Traffic & Safety

US-24G (E-X) / Peterson Rd
El Paso County

RE: Cimarron Hills Southeast Mixed-Use Filing No. 1 (SF2420)

**Figure 13-12c. Emergency Spillway Protection**

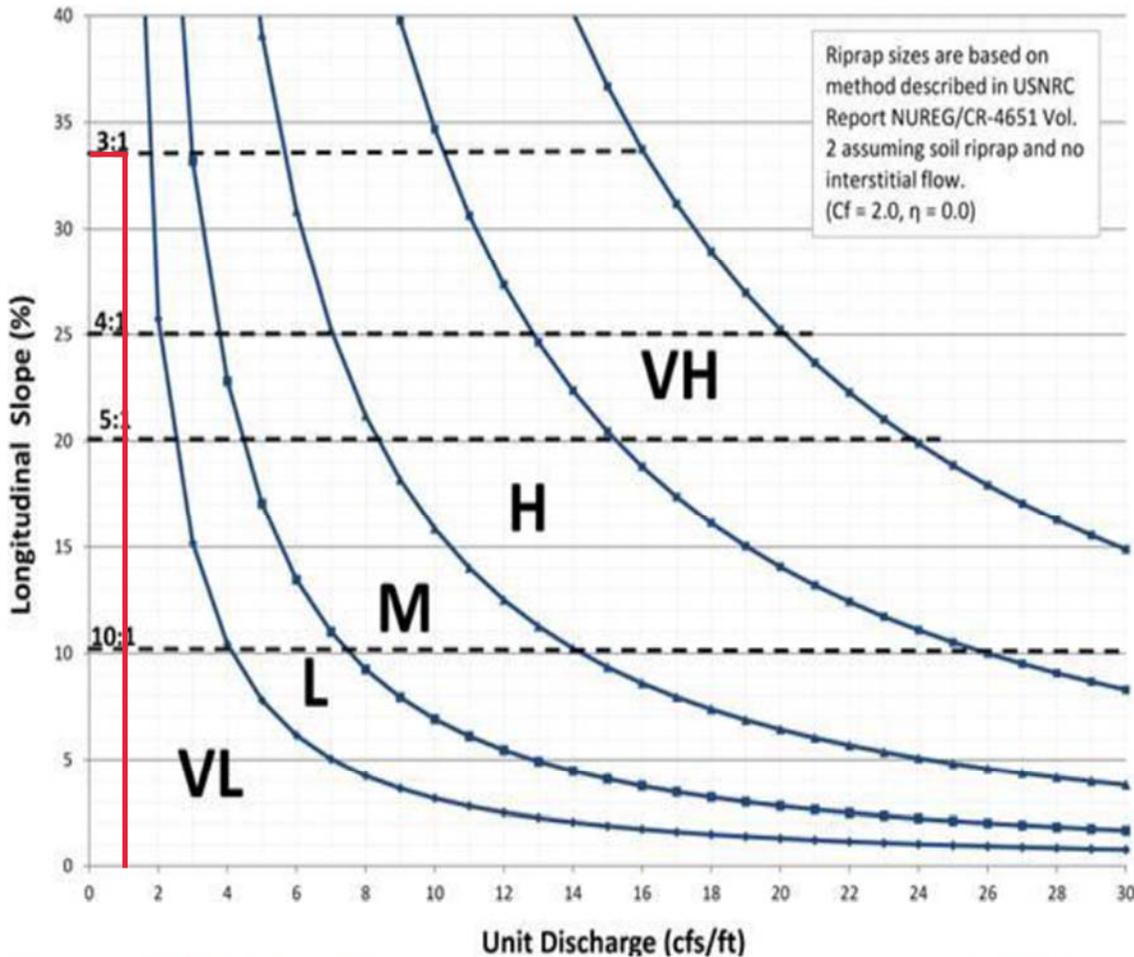
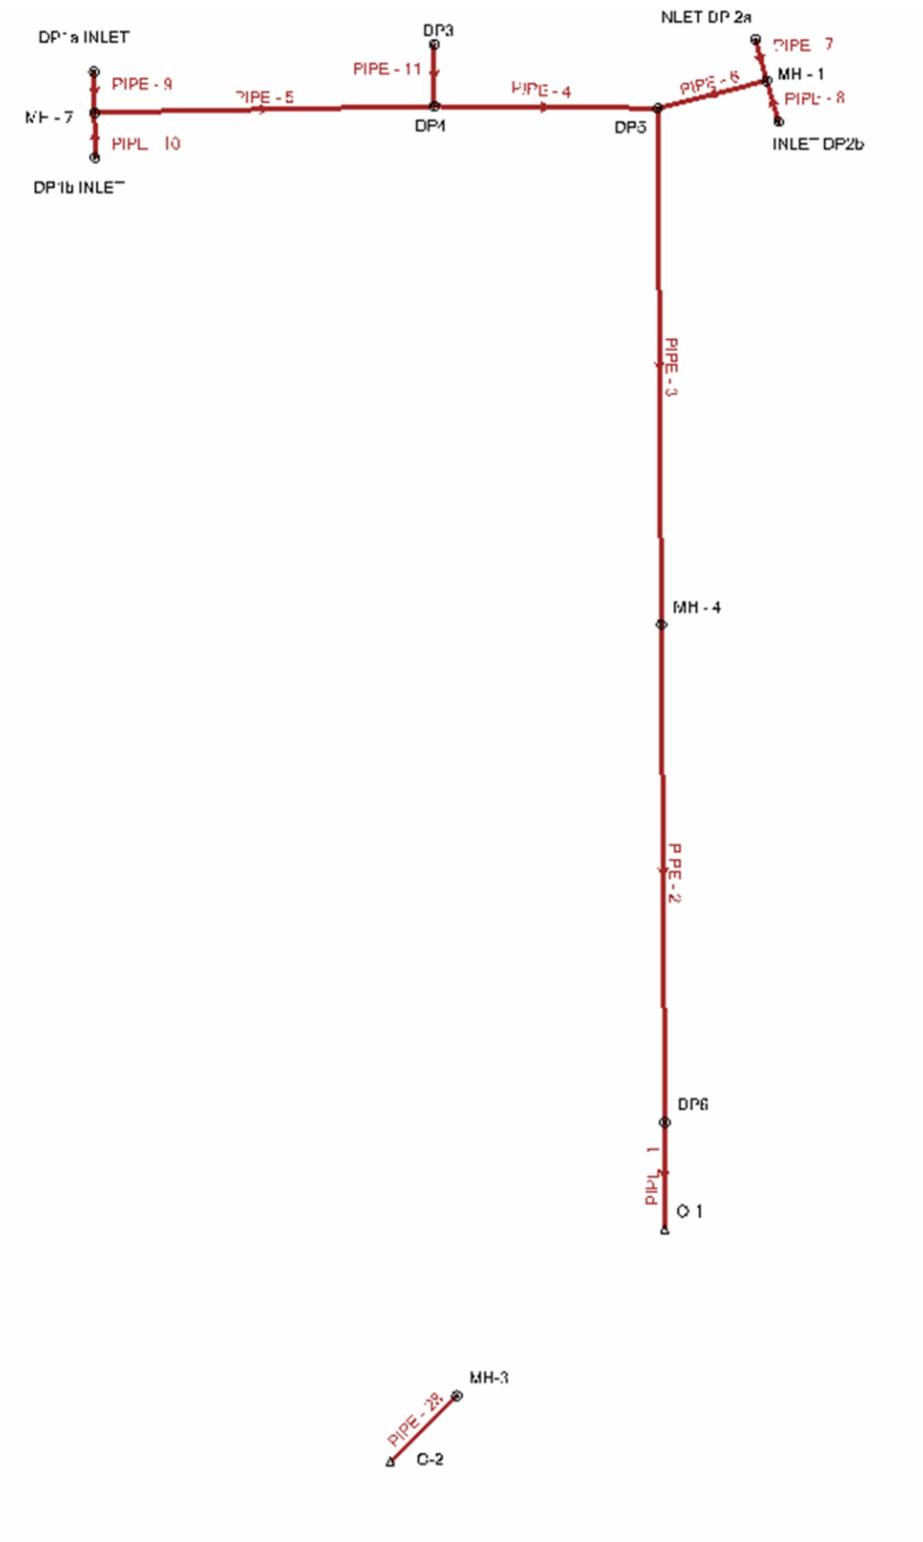
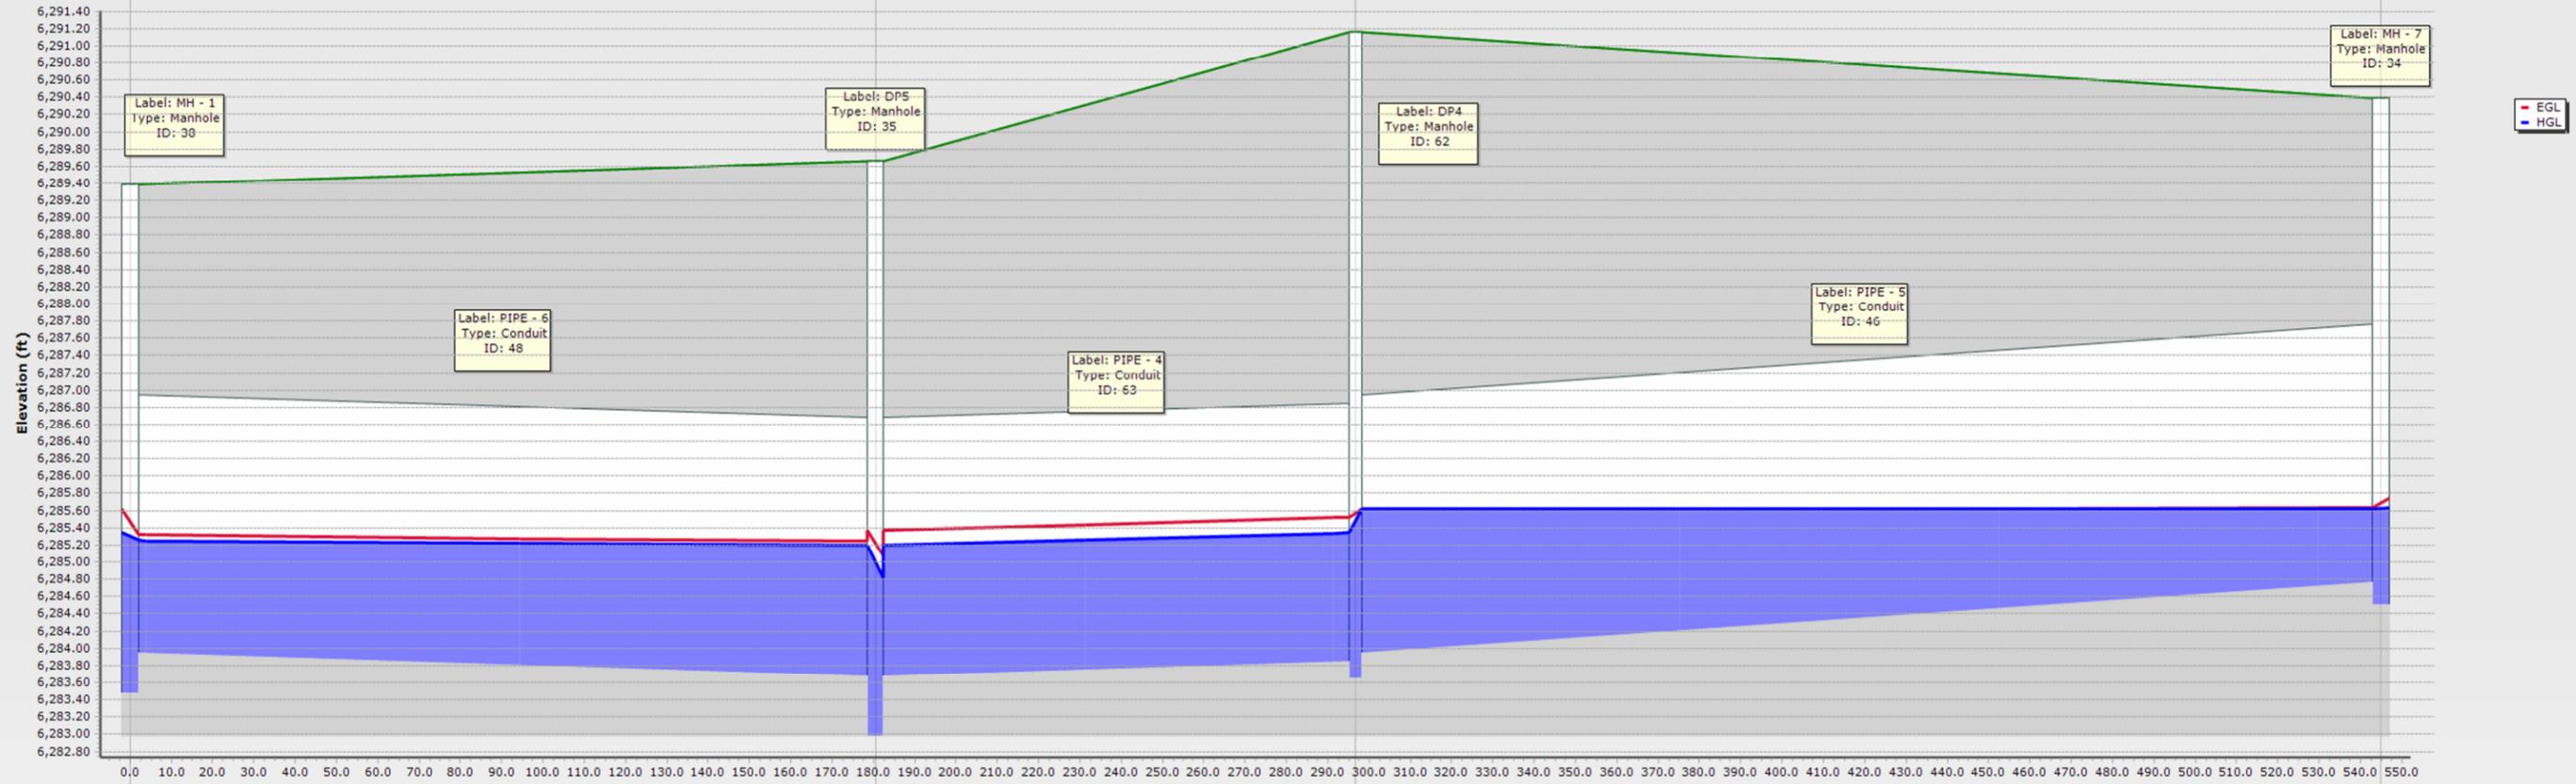
- Are there any significant safeguards in place for overflow of PWQ ponds onto US24? There is an emergency spillway designed to go directly onto US24. These "emergencies" can be fairly frequent and could jeopardize a regional transportation artery, as well as access to Peterson Space Force Base.
- If temporary easements from CDOT are required for construction, a 128/Clearance for hazmat, wetlands, history, and archaeology will be required.

Address the above comments and resubmit documents as necessary.
